# City of Albuquerque Stormwater Construction Site Inspection Report

Project Name and Location	Ca Luz Del Oeste Wine Rd & Dillinger		
Site Contact Name & Agency	Scott Ashcraft Las Ventanas Home	ESC File No.	F11E0021
Date of Inspection	3-9-18	Start/End Time	10:30 / 10:40
Inspector Name, COA Dept.	Curtis Cherne, Stormwater Quality		
Describe Present Phase of Construction	Stabilized

**Re: Drainage Control Ordinance (14-5-2-1) and NPDES CGP Violations for Erosion and Sediment Control and pollution - La Luz Del Oeste Unit 4**

**SILT FENCE**  
NTS

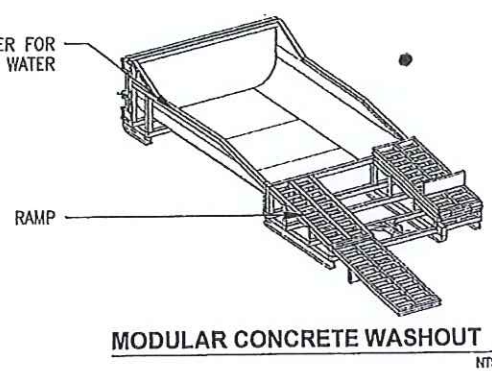
1. Construction entrance needs maintenance.
2. Multiple instances of cement pollution.
3. Silt fence was installed along Dellyne, Ave., however, it was not installed so that it would function to prevent sediment from leaving the site as it was not buried.

Silt fence along Dellyne Ave. not buried; ineffective.

1. Install/maintain the silt fence at the site per approved plan.
2. Install a stabilized entrance per the approved plan.
2. Remove cement pollution material per acceptable methods.

**STABILIZED CONSTRUCTION ENTRANCE**  
NTS

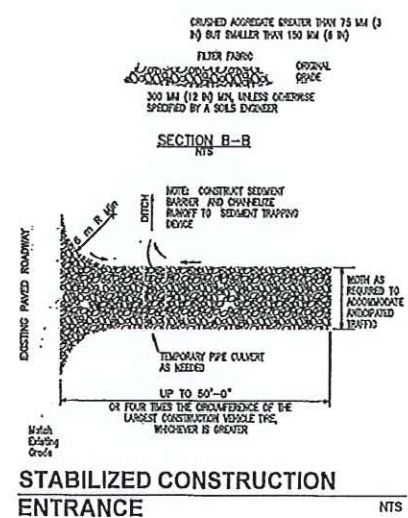
Construction entrance to the site poorly maintained.
